Response to Examiner's Questions.

Prepared by	Elizabeth Verdegem (Team Leader (Strategic) – Development Management)
Date	March 2026
Purpose	Response to ExQ3 for Green Hill Solar Farm (PINS reference EN010170)

- 1.1 This report sets out MKCC's response to ExQ3, issued 18th February 2026, due 24th March 2026.

Title:
Figure 8.1.5 Site Locations and Study Area
Green Hill G

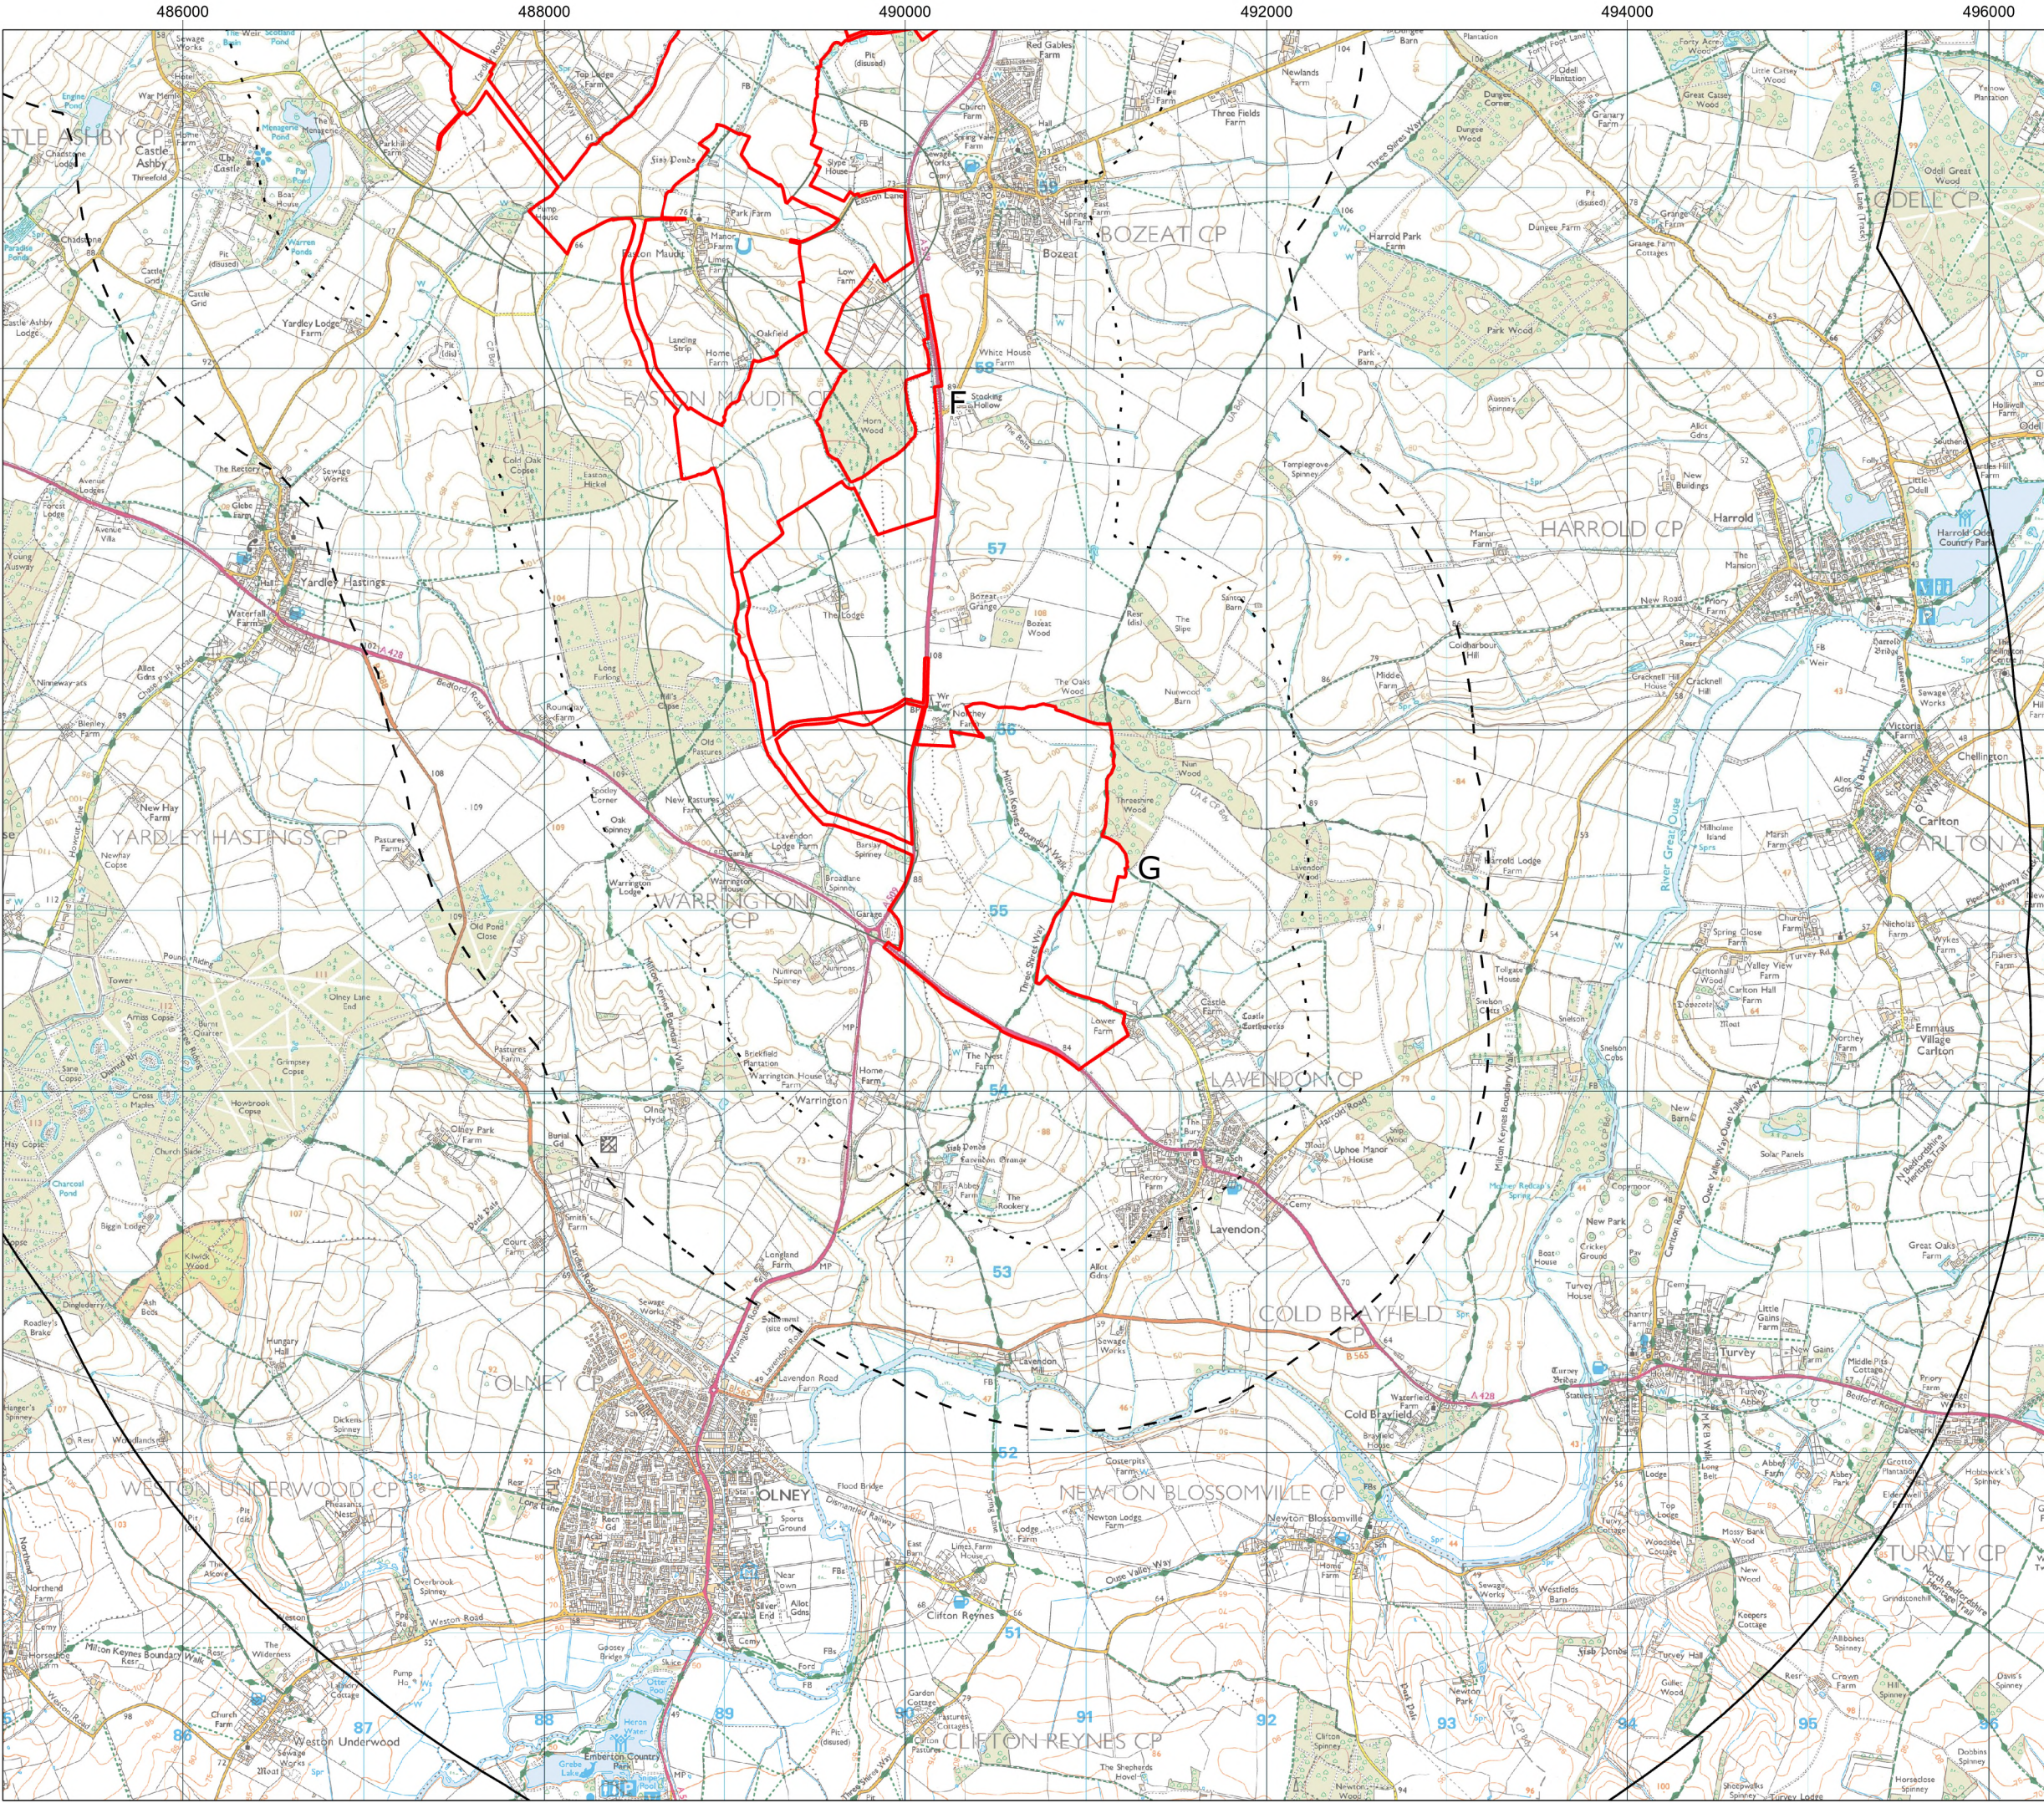
Milton Keynes City Council [REP3-085] raise significant concern that the adjacent woodland and linking boundary features at Site G are of high importance to barbastelle bats, an Annex II species typically considered very rare nationally. Static bat detector surveys (Figure 9.6.7 Bat Static Detector Locations (Green Hill G)) in Appendix 9.6 Bat Surveys (Revision A) [REP1-047] recorded high levels of barbastelle bat activity at location SD38 on the western boundary of Site G (as set out in the applicant's response to MKC 4.15 of the Applicant's Responses to Local Impact Report Responses [REP4-018]). Location SD38 is at the end of a small belt of woodland and across the A509 road from the Barslay Spinney ancient woodland and adjoining hedgerow. The Bat Surveys document states that linear features such as hedgerows and small woodland blocks provide bat flight paths and foraging resources. It states that broadleaved woodland offers a high-quality foraging habitat for bats. A tree with a high suitability for roosting bats was recorded (Figure 9.6.14 Bat Ground Level Tree Assessment Results (Green Hill G)) in [REP1-047] in close proximity to location SD38. Trees with moderate suitability for roosting bats were identified in Barslay Spinney and within the Cable Route Corridor (CRC) to the west of the spinney (9.6.19 Bat Ground Level Tree Assessment Results (Cable Route 5 of 5) [REP1-047]. Bat activity surveys were not carried out within the CRC. Work No 5B for the CRC passing west from the A509 road close to location SD38, and adjacent to the Barslay Spinney ancient woodland and a hedgerow to its west, comprises works to lay electrical cables including laying down of access tracks, roads, drainage infrastructure, cable laying, tunnelling, boring and drilling works and temporary construction and decommissioning laydown areas which may include areas of hardstanding, car parking, materials and equipment storage, site and welfare offices and workshops. A temporary haul route would be implemented alongside the cable route (Outline Ecological Protection and Mitigation Strategy (Revision B)) [REP4-010], Section 3.4, which would require the use of HGVs to construct. The CRC would contain no ecological buffers, as set out in the Schedule of Protective Ecological Buffers [APP-095]. As features such as the ancient woodland and adjoining line of hedgerow and trees across the road from location SD38 may provide flight paths and foraging resources for the barbastelle bat, do you consider that the absence of ecological buffers to these features adjacent to the CRC may result in harm to the protected species and relevant habitat?

Response: In the absence of survey work to understand how bats utilise the CRC, it is difficult to accurately predict the impacts which may occur to the protected species in the absence of mitigation. Habitats, however, may be impacted by the proposed works if works such as boring, drilling, tunnelling, laying of hardstanding or tracking of heavy machinery occur within the RPA of habitats such as hedgerows, trees and woodland. Impacts to root systems can kill vegetation and thus, impact the linear connectivity of wildlife corridors. Equally, if lighting is used close to these features, this may impact light sensitive species such as Barbastelle, the worse case being such species avoid the affected areas altogether or abandon any roosts which may be present. Noise, vibration and dust may also have an impact.

In the absence of survey information, if presence of protected species is assumed at a level similar to that identified in Site G, particularly at SD38, it is considered harm to protected species may occur from the proposed works in the absence of mitigation or ecological buffers. Further survey

work to the CRC would be required to inform mitigation or potential licensing requirements if bat roosts in trees were to be affected. Implementation of ecological buffers would be preferred.
